ENG-PUDSP22001-R1-GEC.pdf Markup Summary

PUDSP221

**CORE ENGINEERING GROUP**  
15004 1ST AVENUE S.  
DENVER, CO 80232  
PHONE: 719.570.1100  
CONTACT: RICHARD L. SCHINDLER, P.E.  
EMAIL: Rich@cegi.com

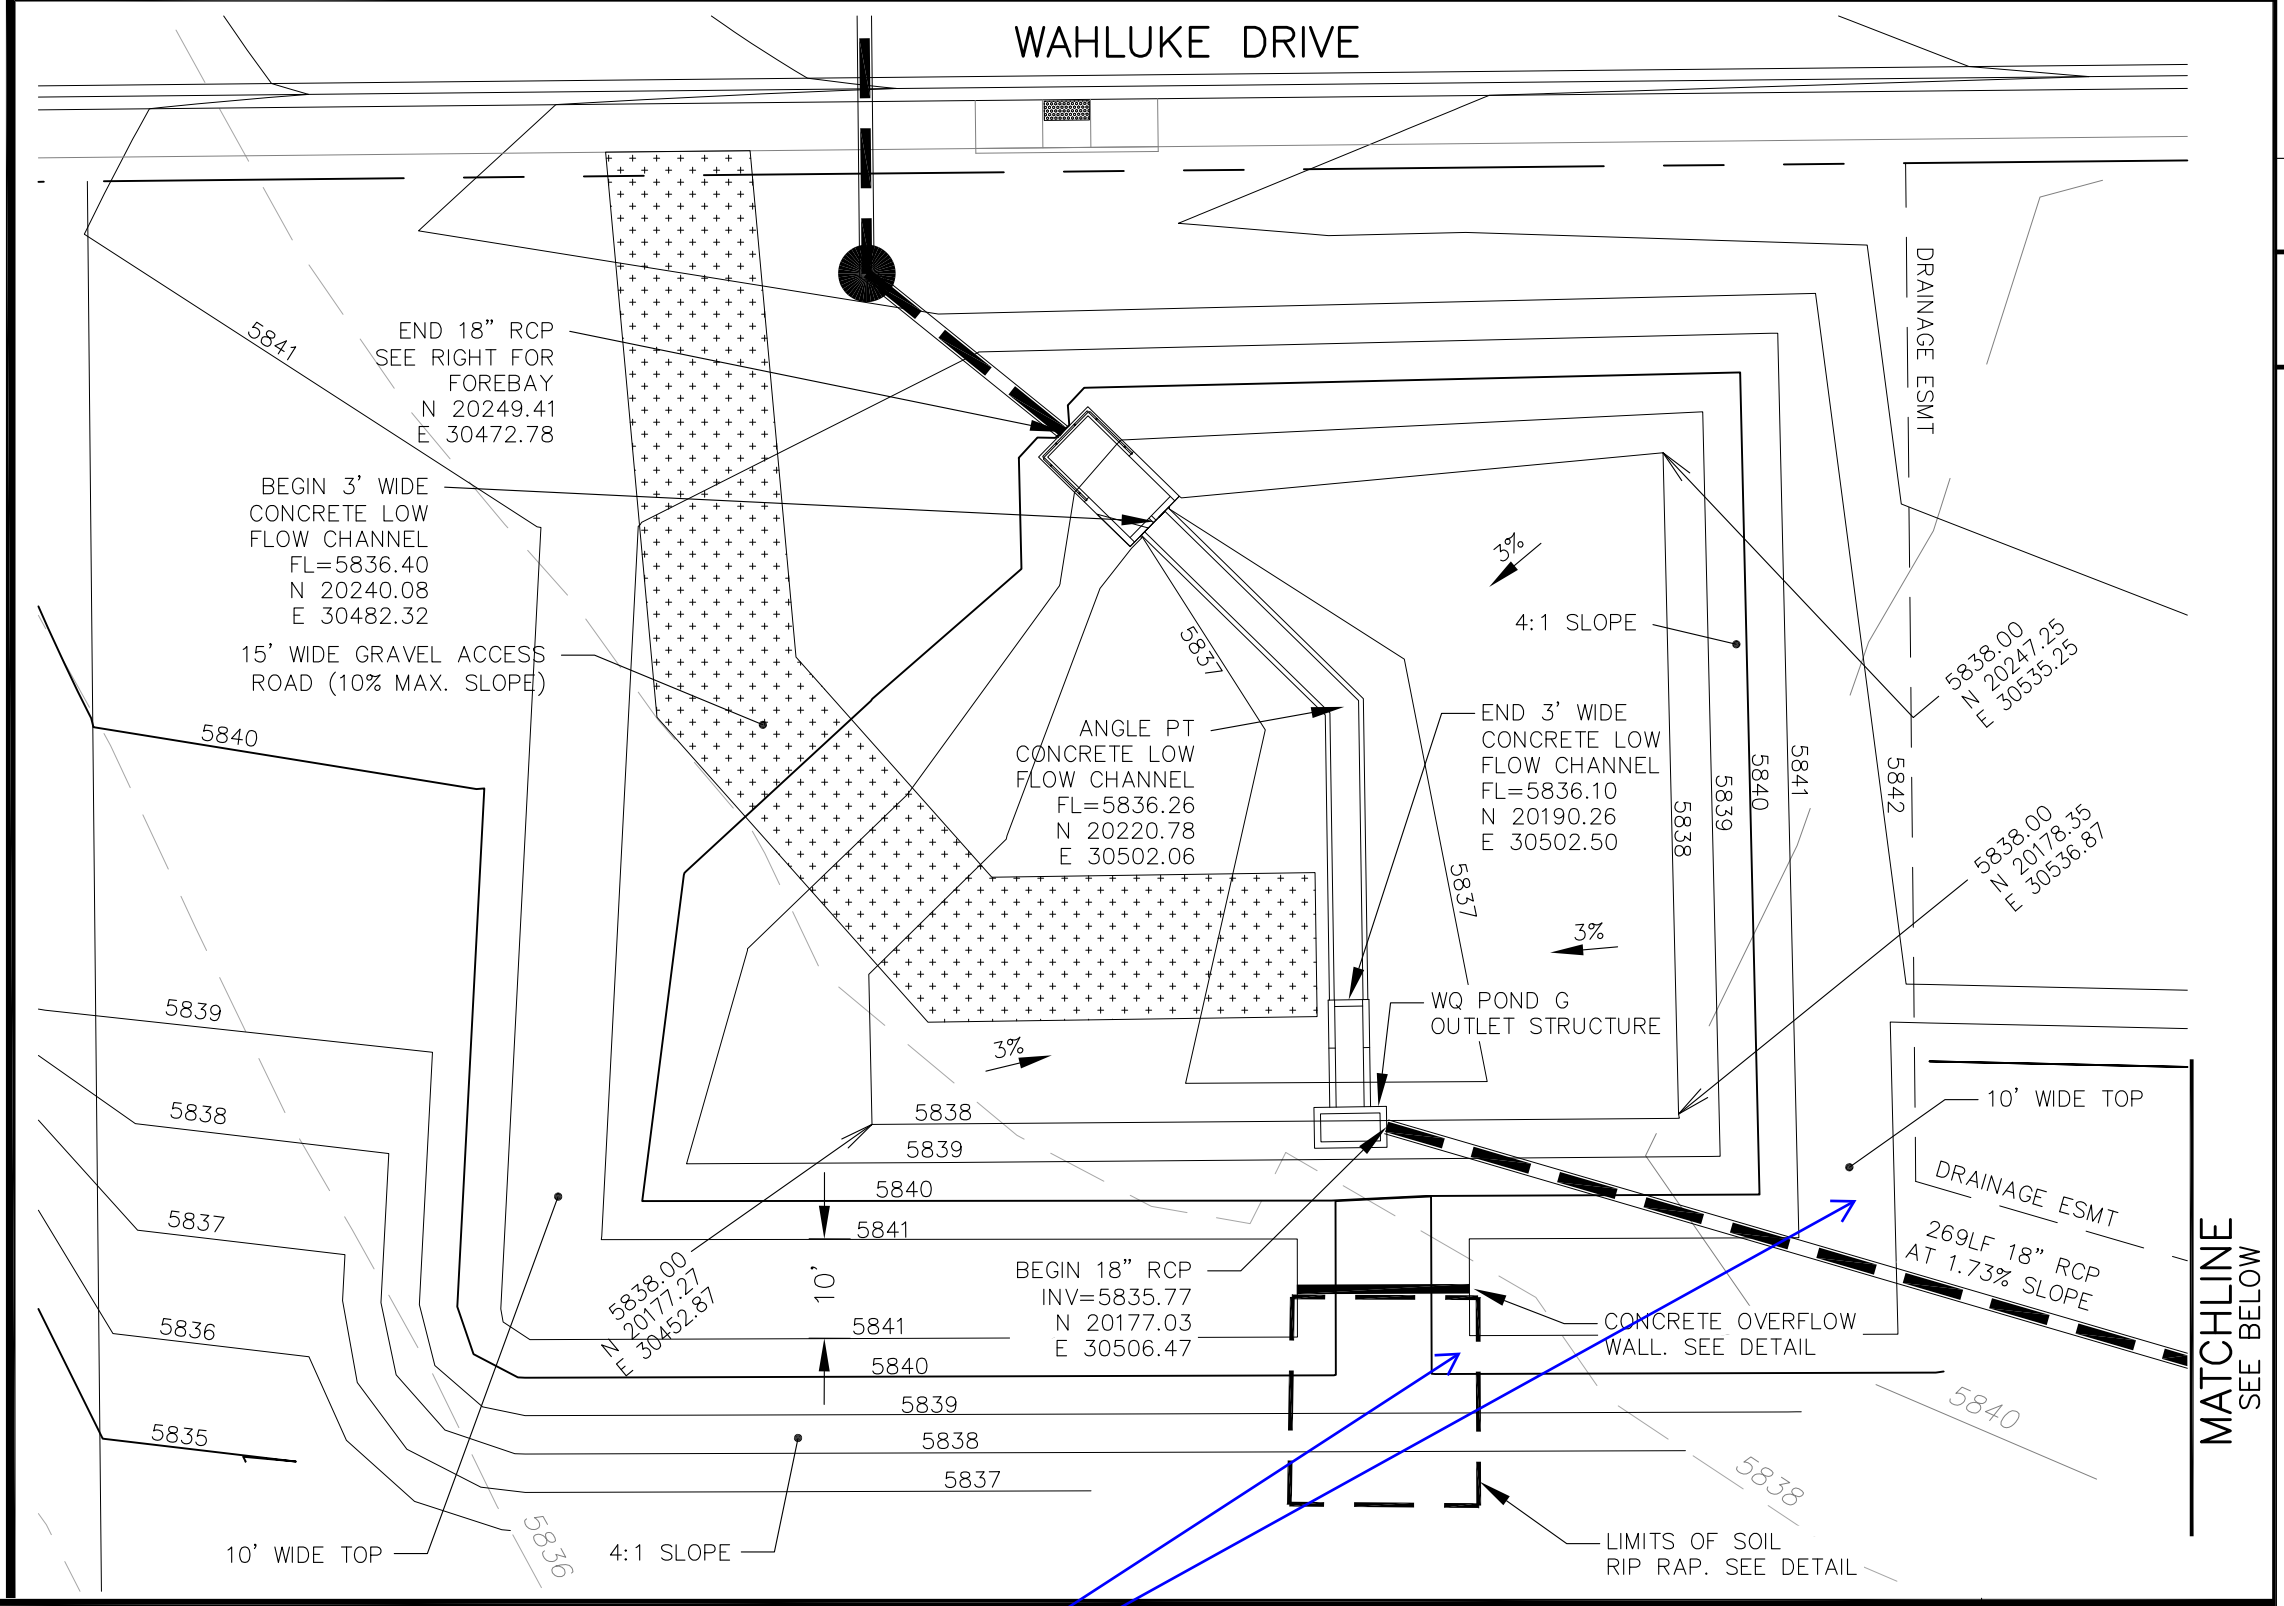
PDR pg 110 shows a Type C grate. Revise to remove discrepancy.

provide detail with LxWxH dimensions and size of riprap.

double check volume calcs. I get 0.0033 ac-ft, whereas pdf pg 125 of PDR states min should be 0.004 ac-ft.

6ft x 12ft x 2ft / 43560 sqft/ac = 0.0033 ac-ft.

Remove "WQ." Per pdf pg 28 of the PDR, this is a full spectrum detention pond, not a WQ Pond.

provide detail with LxWxH dimensions.
